CONFIDENTIAL: Submission to the Parramatta Light Rail Stage 2 SSI-10035

This submission has been prepared by Keylan Consulting Pty Ltd on behalf of The Billbergia Group (Billbergia) in response to the Transport for NSW's (TfNSW) Parramatta Light Rail (PLR) Stage 2 Environmental Impact Statement (EIS) which is currently on public exhibition until 16 December 2022. This submission incorporates input from AJC Architects.

Figure 16: Overview map - New bridge between Camellia and Rydalmere.

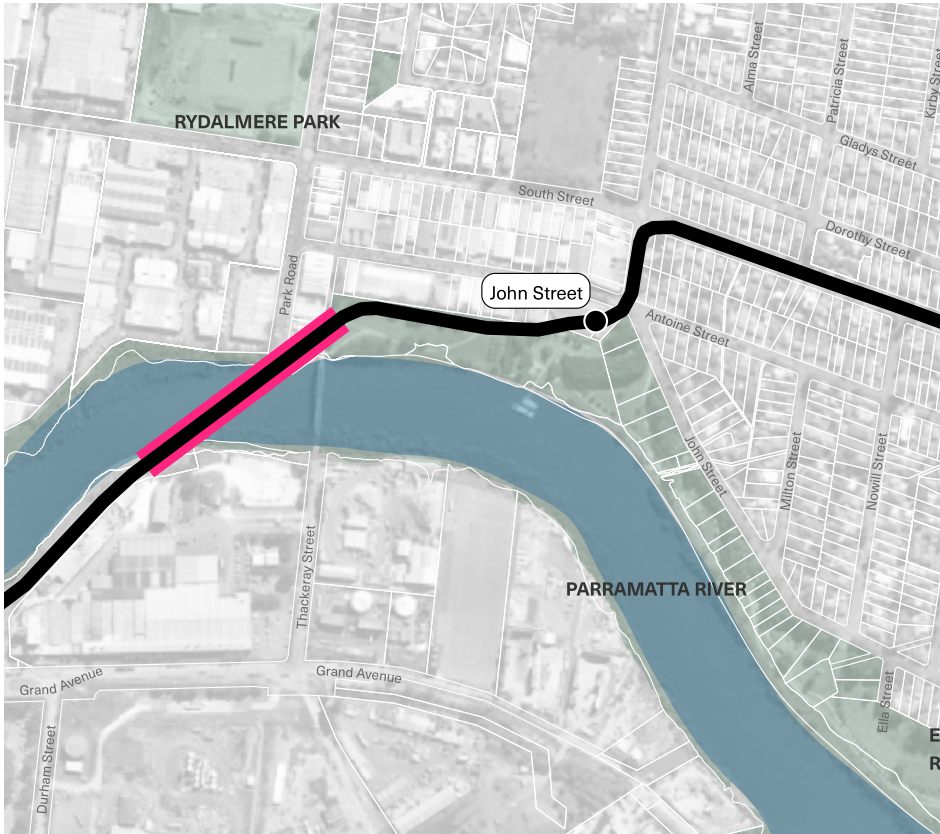
In their 2019 Planning Proposal and in subsequent submissions to various policies and plans including the PLR Stage 1, Billbergia has identified that a bridge further east connecting Thackeray Street in Camellia to Park Road in Rydalmere would be the more appropriate bridge location. This is based on the following reasons:

- there is an existing pedestrian crossing at this location
- it more efficiently connects Camellia to Victoria Road and suburbs further north
- it is more easily adaptable to efficiently serving private vehicles, pedestrians, and light rail simultaneously
- it will likely be the more cost effective as public roads already exist on both sides of the Parramatta River and extend to the foreshore

7. The proposed light rail bridge crossing to be reviewed and for a crossing between Thackeray Street and Park Road to be considered instead.

Figure 18: Cross section 01 - Sandown Line (indicative only - subject to design development).

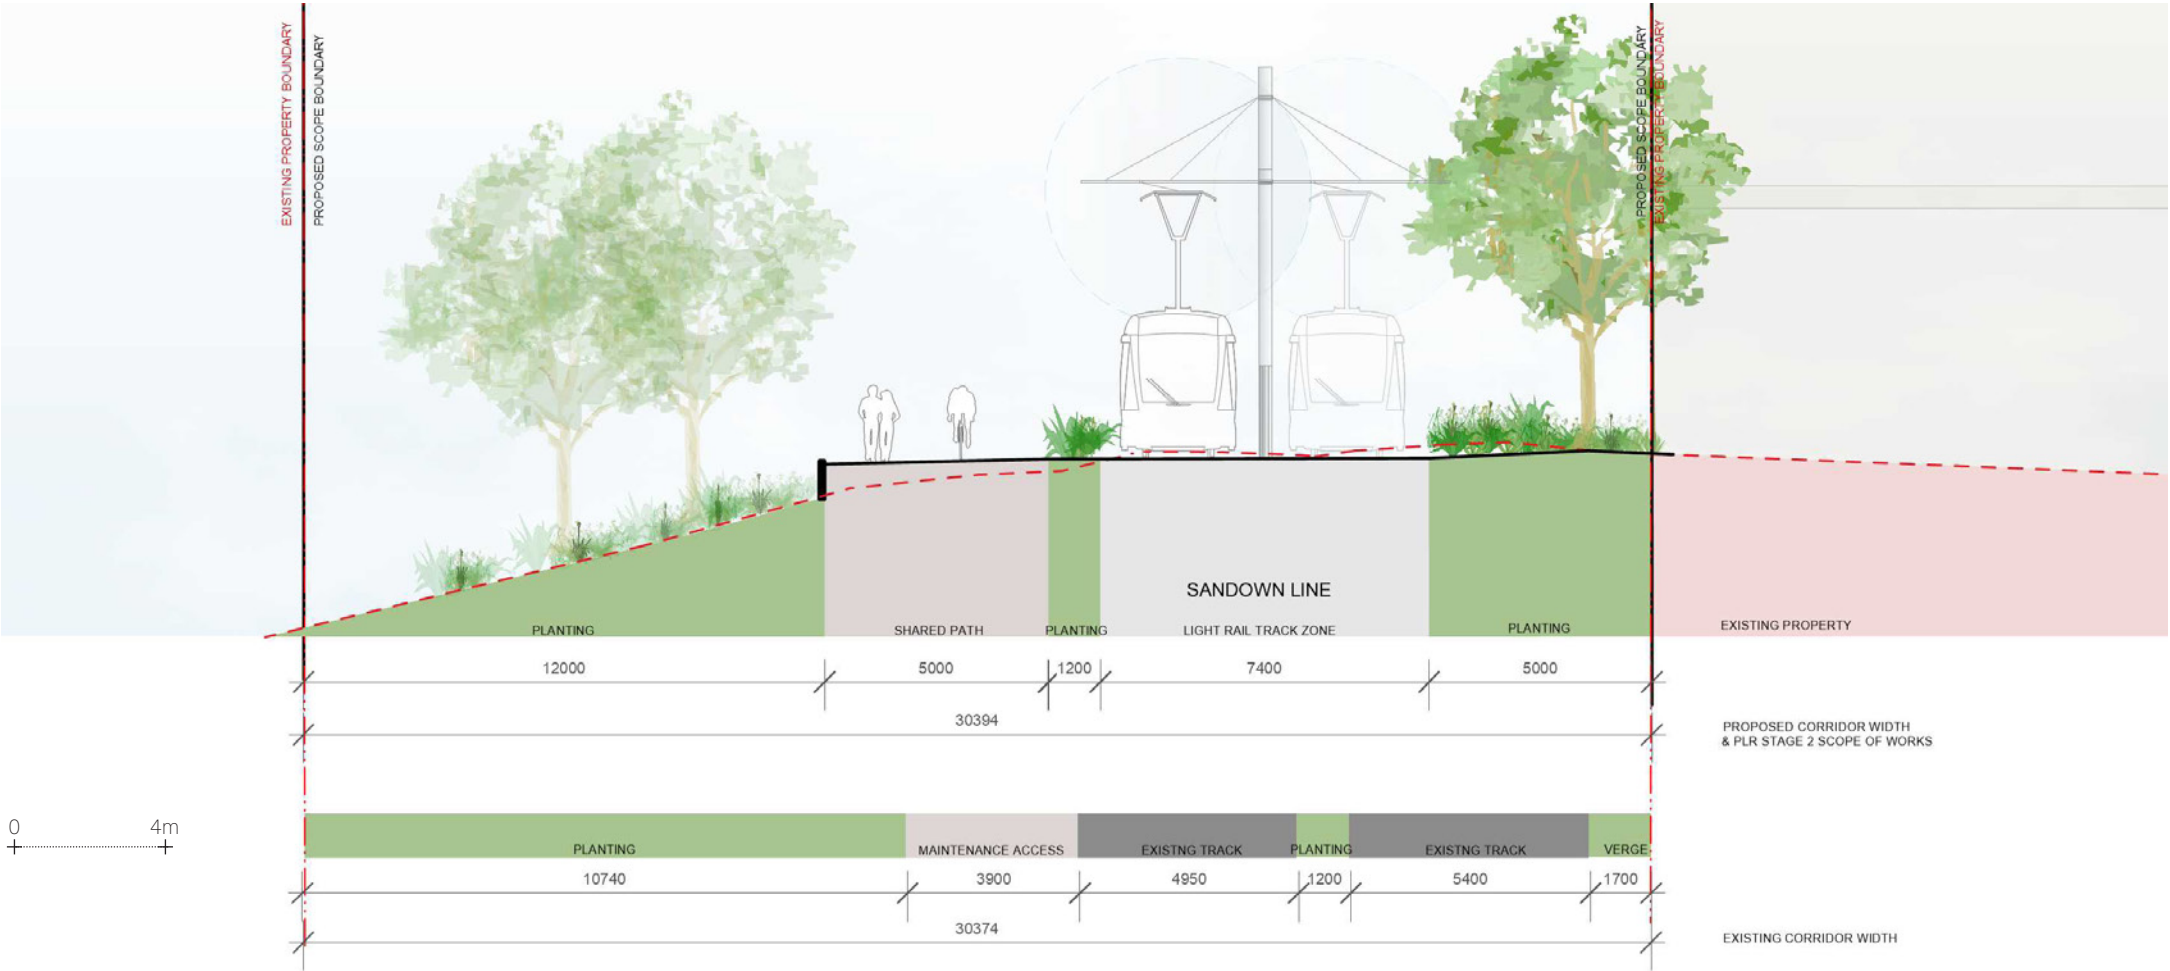
The section of the Sandown Line that passes through the future Camellia Town Centre is proposed to be a 30m rail reserve that will incorporate light rail, station infrastructure, roadway, pedestrian paths, and a verge for parking and street trees as shown in the figure below.

As the Sandown Line is approximately 20m wide, we anticipate that this 30m reserve will encroach into Billbergia's site boundaries and will result in a loss of approximately 10m of land.

Billbergia's position is that a 30m reserve is excessive and shared pathways and activation of street could instead occur within a 20m reserve. To achieve this, it is suggested alternative design solutions be sort such as the removal of the verge and reduction of traffic lanes down to one. This is considered appropriate as parking should not be encouraged in the Camellia Town Centre given the transit orientated nature of the precinct. These recommendations have been informed by advice from AJC Architects.

5. Alternative design solutions to be considered to reduce the width of the rail reserve in proximity to the Camellia Town Centre from 30m to 20m.
6. Clarification of any land acquisition requirements for Billbergia's site as a result of the proposed rail reserve in proximity to the Camellia Town Centre.
